Application No: FG/114/21/HH
Site Address: 23 South Drive Ferring BN12 5QU
Description of works: Extensions and internal and external remodelling of existing dwelling to create a 4no. bedroom dwelling with double garage including single storey rear extension, replacement and reformation of roof to create second floor accommodation with rear balcony, associated landscaping.

Thank you for your internet representation made on 29th July 2021 which has been recorded as an objection with the comments as follows:

Ferring Parish Council objects to this proposed development as it is out of keeping with the adjacent properties, fails to respect the style and character of the area and would undermine the sense of place in this village setting, contrary to the made Ferring NP.

Street Scene Elevations -
Existing & Proposed

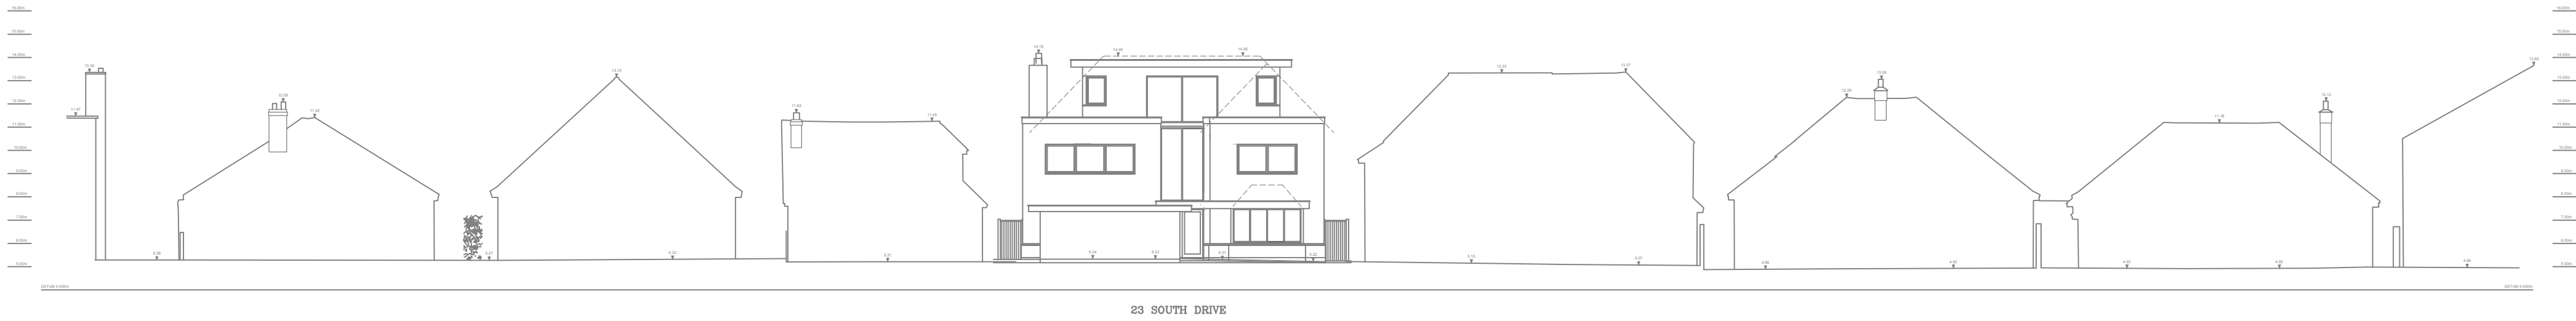
The design features are particularly significant here as this site is within a recognised Area of Special Character as outlined in the Ferring NP and incorporated within the ADC Local Plan. Such a contrasting design and high-level mass would be in direct contrast to the established traditional pitched and tiled roofs of neighbouring properties and would undermine the character of the area.

The second floor windows and large balcony area would impact on the visual harmony of the properties in this Area of Special Character, both from the street scene to the north and from the beach and Patterson's Walk to the south. While neighbouring properties also back onto Patterson's Walk, privacy of their gardens can currently be achieved through landscape design and planting. This development would create a high level viewing platform overlooking the gardens in such a way as to deprive adjacent properties of that privacy and seclusion.
